## **The Examining Authority's (ExA's) first written questions and requests**

The following table sets out the Examining Authority's (ExA's) initial written questions and requests in relation to the proposed Yorkshire and Humber CCS Cross Country Pipeline. Responses are required by **Thursday 18 December 2014**. Please note that if this deadline is missed the ExA is not obliged to take account of your response.

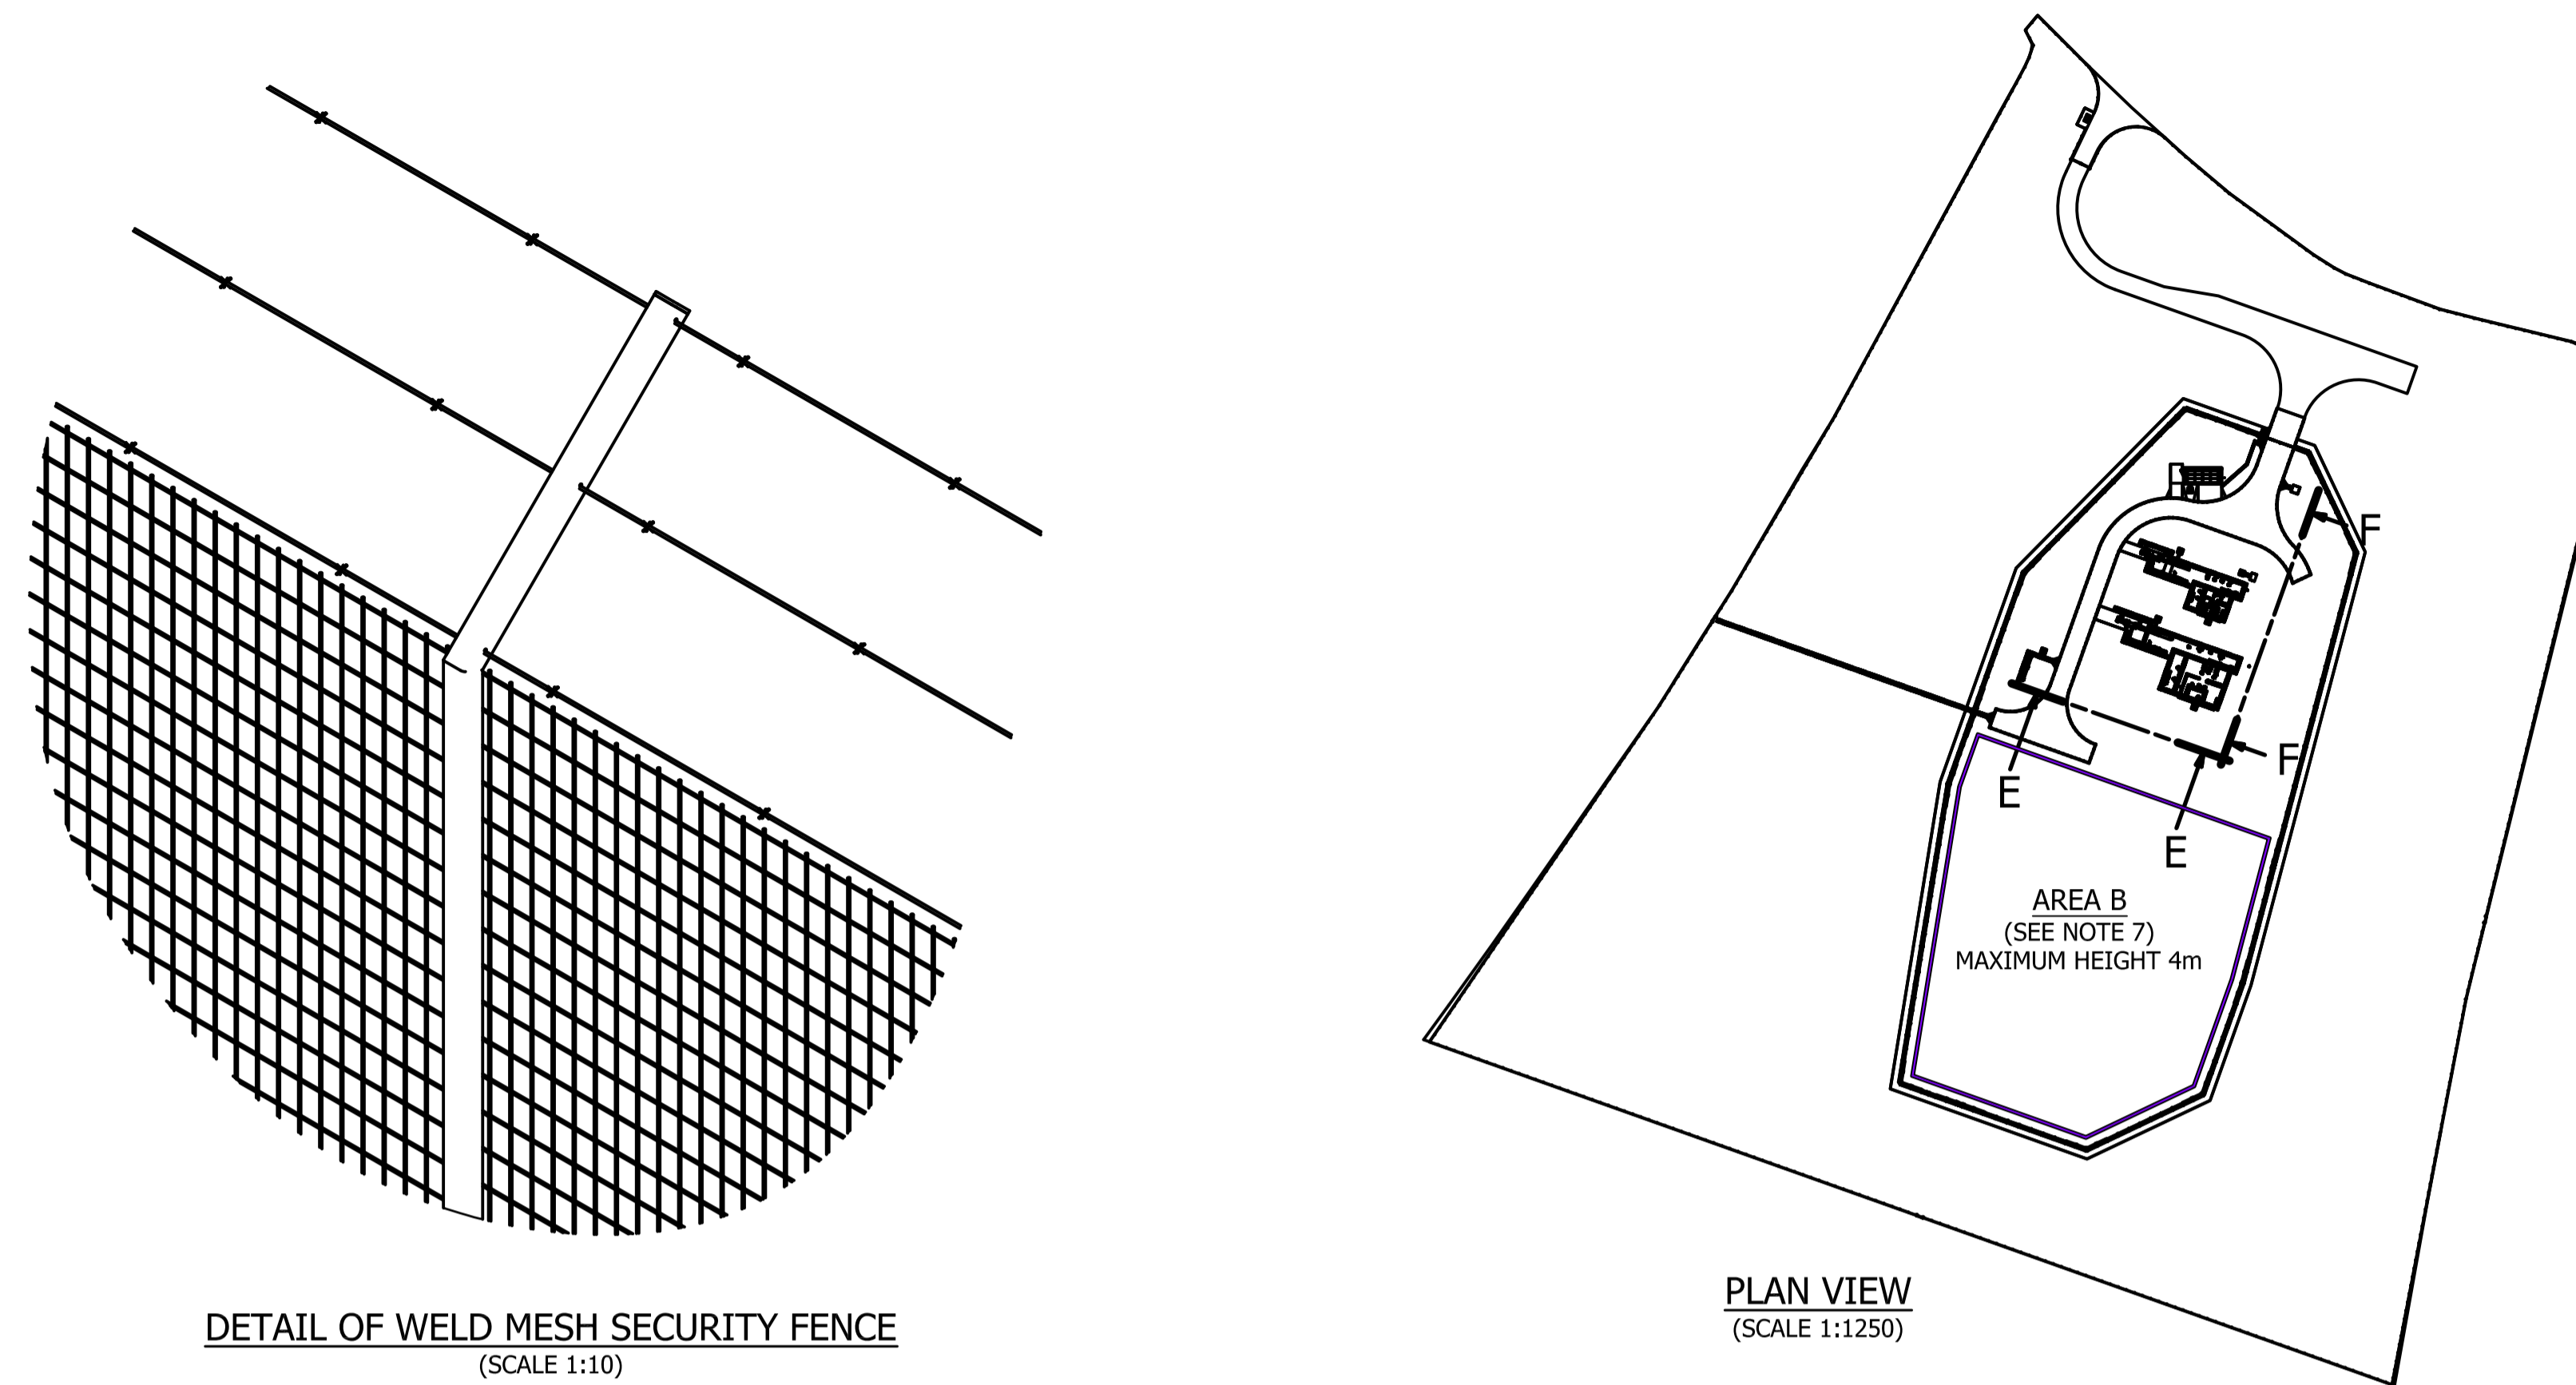
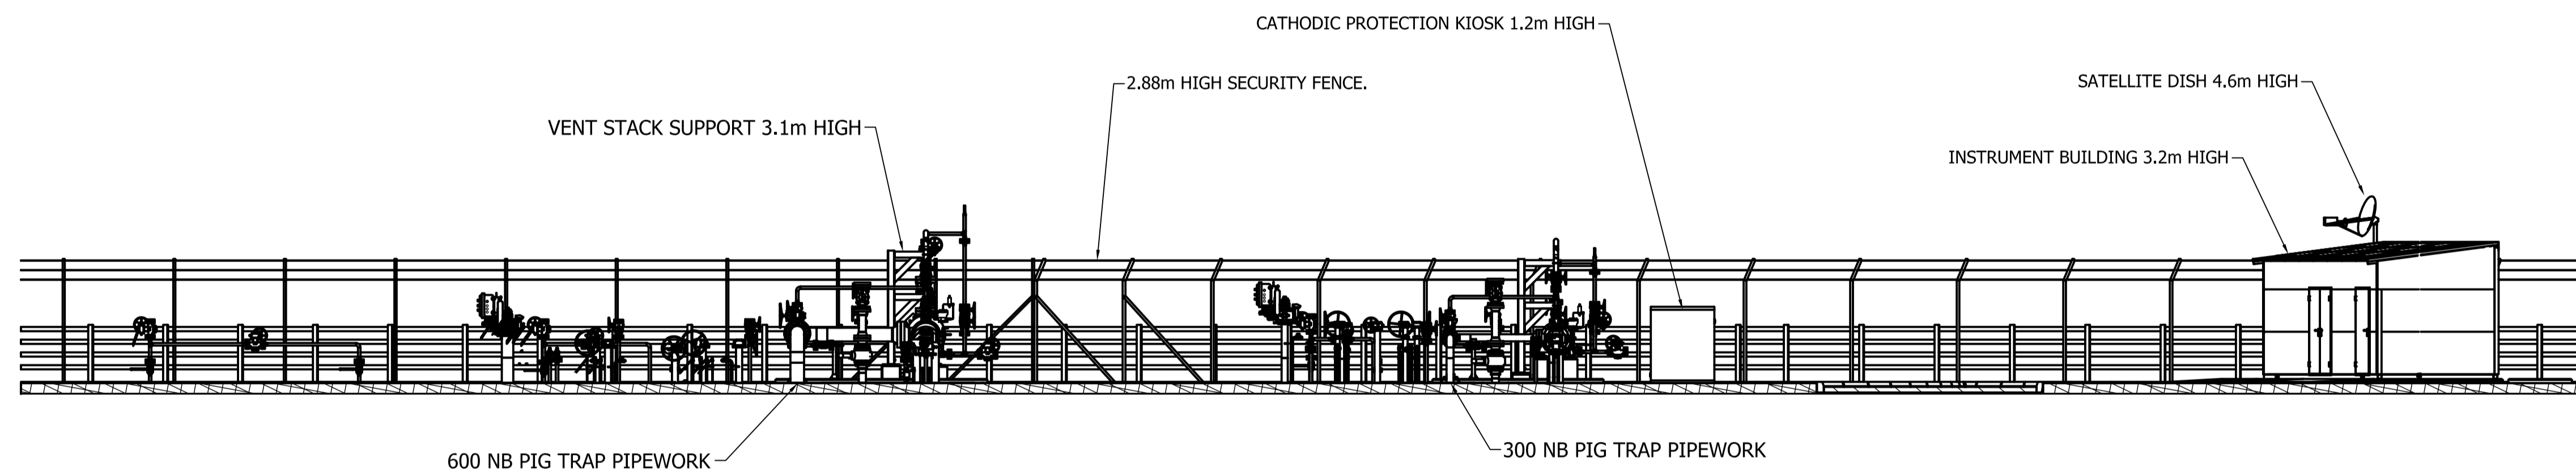
<b>Q1.4</b>	Applicant	Can the applicant explain how the elevations of the Drax PIG trap and the Camblesforth Multi Junction by 1m above ground level (and 0.3m at the Skerne Block Valve) is sufficient to mitigate against potential flood risk (ES Chapter 3 para 4.1.23)?
<b>Q1.5</b>	Applicant	Can the applicant explain how many employees would work at the Pumping Station 24/7 both during construction and upon completion?
<b>Q1.6</b>	Applicant	Can the applicant explain the construction sequence and timing as a development of the table at 7.5 (para 1.5.1). For example, would the pipeline be built in sections between or either side of the block valves and what would be the approximate speed of construction within a section? Would the sections be self contained and is there an intended sequence of sections within one season - April to September?
<b>Q1.7</b>	Applicant	The construction of the pipeline would commence in 2018 and is anticipated to take one season (beginning in April to the end of September) (ES Chapter 3 paragraph 5.2.29). This construction period has been assumed throughout the ES. Can the applicant describe what assurances there are that

Q1.13	Applicant	It is noted that Area B of the Camblesforth multi-junction (an outline area providing capacity for a

Ref No.	Respondent:	Question:
		further three PIG Traps that would be needed to accommodate future connections to the pipeline but will be grassed in the meantime (para 4.2.1 of ES Chapter 3)) and Barmston pumping station are being applied for at outline level. Parameter plans have been produced for each of these project components which include the maximum dimensions of buildings. Can the applicant and local planning authorities consider whether the DCO is sufficiently detailed for these components and how would these “reserved matters” be controlled?
Q1.14	Applicant	Maximum heights for Area B of the multi-junction are stipulated in ES Chapter 3 Table 3 but have not been included on the planning arrangement (Document 2.25), the details of which must be accorded with during construction under DCO requirement 6. Can the applicant consider whether Document 2.25 should be amended to include the maximum heights? And what should be the time limit in the DCO for construction of Area B?
